Your Ref: F/26/17/DOC

Town & Country Planning Act 1990 (as amended)
Town and Country Planning (Development Management Procedure) (England) Order 2015
Application for approval of details reserved by condition imposed under planning permission
F/15/16/PL relating to condition No. 3 (SuDS System and No. 4 (Landscaping scheme)
1 - 4 Holm Oaks Land Adj to Northwood House, Burndell Road, Ford

Arun District Council have decided to **REFUSE details reserved by condition for the following reasons:**

**Surface Water
Drainage Layout**

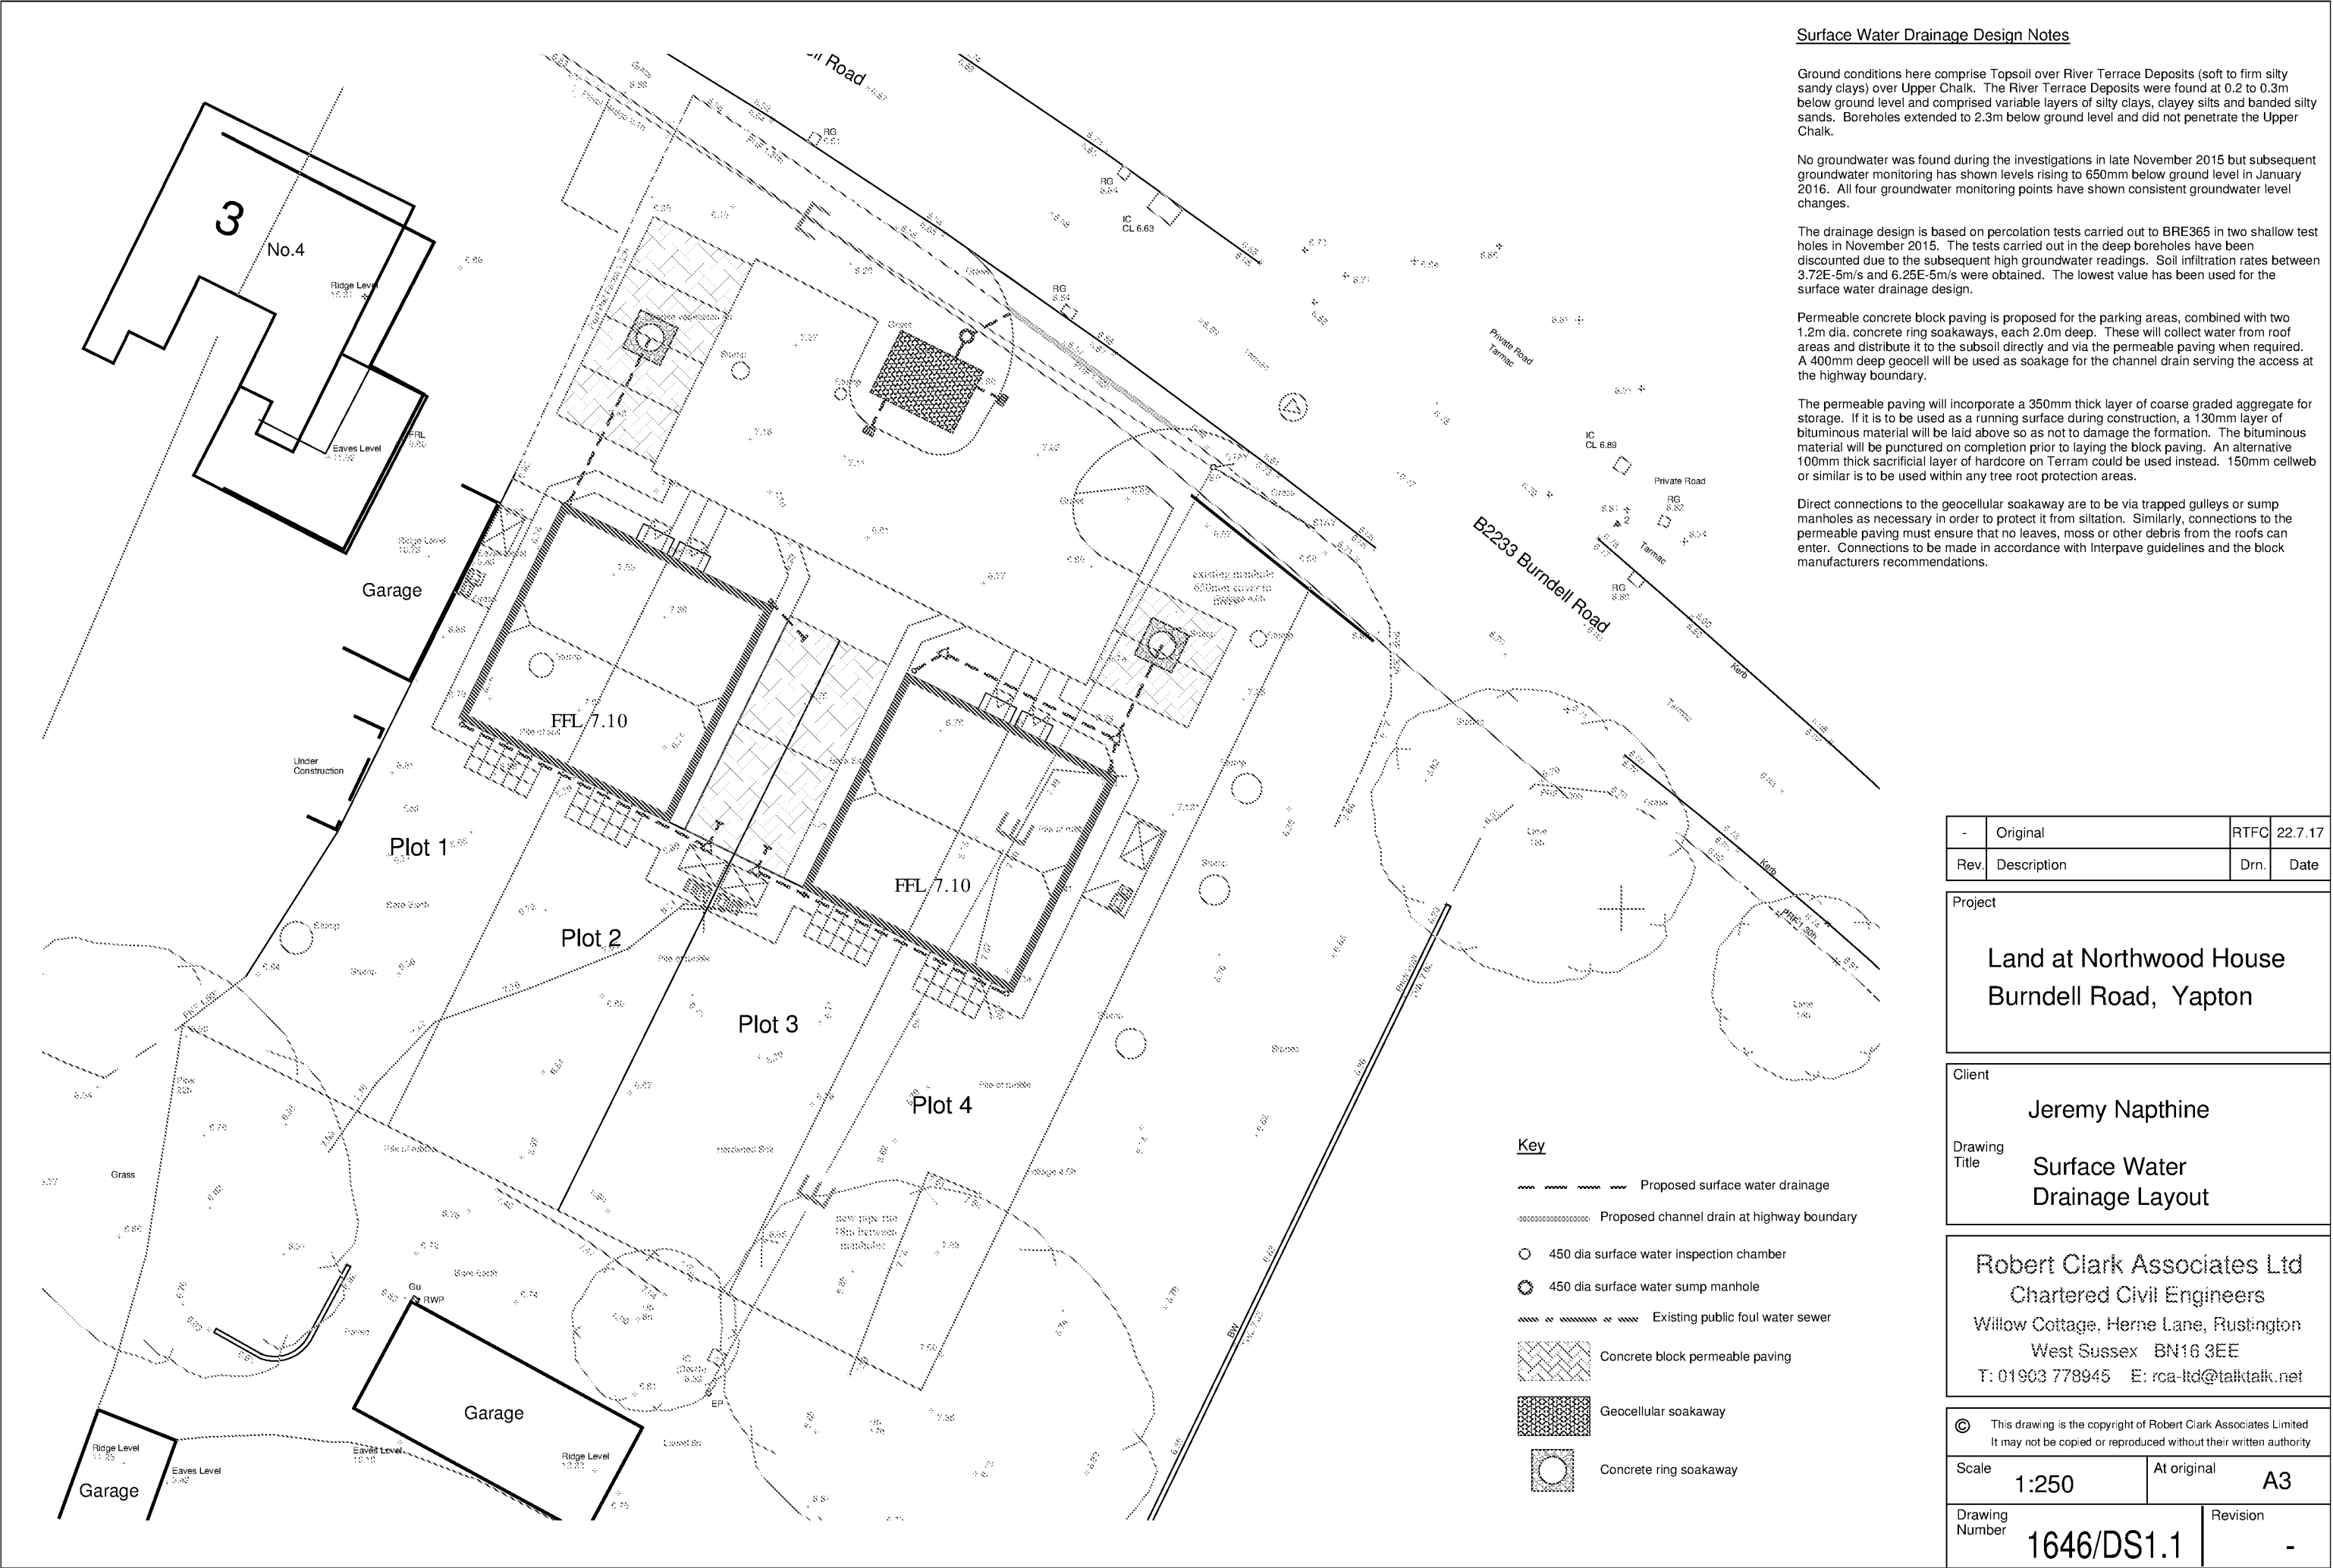
2. It appears that the current surface water drainage design deviates from the originally approved scheme. Also, what exists on site does not correspond to what is shown on the current drawings.

3. The three soakaways shown at the front of the site are not visible. The two at the rear in the rear gardens also do not exist in the positions shown, although there are two manhole covers visible in the rear of plots 1 and 3, which may suggest that their positions have been moved. A channel drain exists where the driveway meets the public highway. The applicant needs to clarify what has been built on site and update the drawings accordingly.

4. Show how the channel drain is connected into the system.
5. The scheme has a fundamental problem in that the proposals/calculations are partly utilising deep soakage and storage. The basis of the original scheme was to rely on shallow

soakage/storage due to the high water table (650mm below ground level) and with also the better percolation rates being achieved at shallow depth. Therefore, a large proportion of the storage in the ring soakaways is not unusable in high groundwater conditions and cannot be taken account of in the calculations. If ring soakaways are to be used as a means of providing pipe connectivity/water distribution, then they need to be physically connected to shallow storage, where suitable capacity can be provided, and favourable percolation rates made use of. It should be noted that the potential ring soakaways in the rear of the properties may not have any connection to shallow storage features and are therefore probably unable to accommodate the design storm. The hydraulic calculations will need to reflect the above (they currently do not).

6. An outflow/overflow is shown from the permeable paving. Why is this needed? Has it been built? The original scheme was to solely rely on shallow soakage/storage and therefore this type of connection would not be permitted. If the connection has been made, then it would have been made to the highway drain in Burndell Road. Did WSCC approve this? The notes on the drawing mention it discharging to a channel drain?, whilst item 1.9 of the Ambiantal report refers to a discharge to a ditch? Has the permeable paving been tanked as a result?

7. The percolation rate used in the calculations was the best rate achieved in testing and should not have been used. Either the worst rate or an average would only be permitted. Please note that percolation through the base of ring soakaways should not be taken account of in the hydraulic calculations, not to mention anything deeper than 650mm below ground level. Due to the likely construction of the ring soakaways, this likely rules out the entire ring soakaways soakage potential and needs to be reflected in the calculations .

8. The drawing should clearly indicate the perimeter of the permeable paving (assumed green shaded area) - add key.

9. Indicate finished surface levels for the permeable paving on the drawing, including levels on the channel drain. Has the permeable paving been laid with a flat formation level? - indicate levels on drawing

10. Pipe diameters/invert levels and gradients need to be specified for all pipes.

11. Catchpits required immediately upstream of all soakaway structures.

12. Full construction detail drawings will be required for catchpits/permeable paving/soakaways, including how the soakaways interact with the permeable paving.
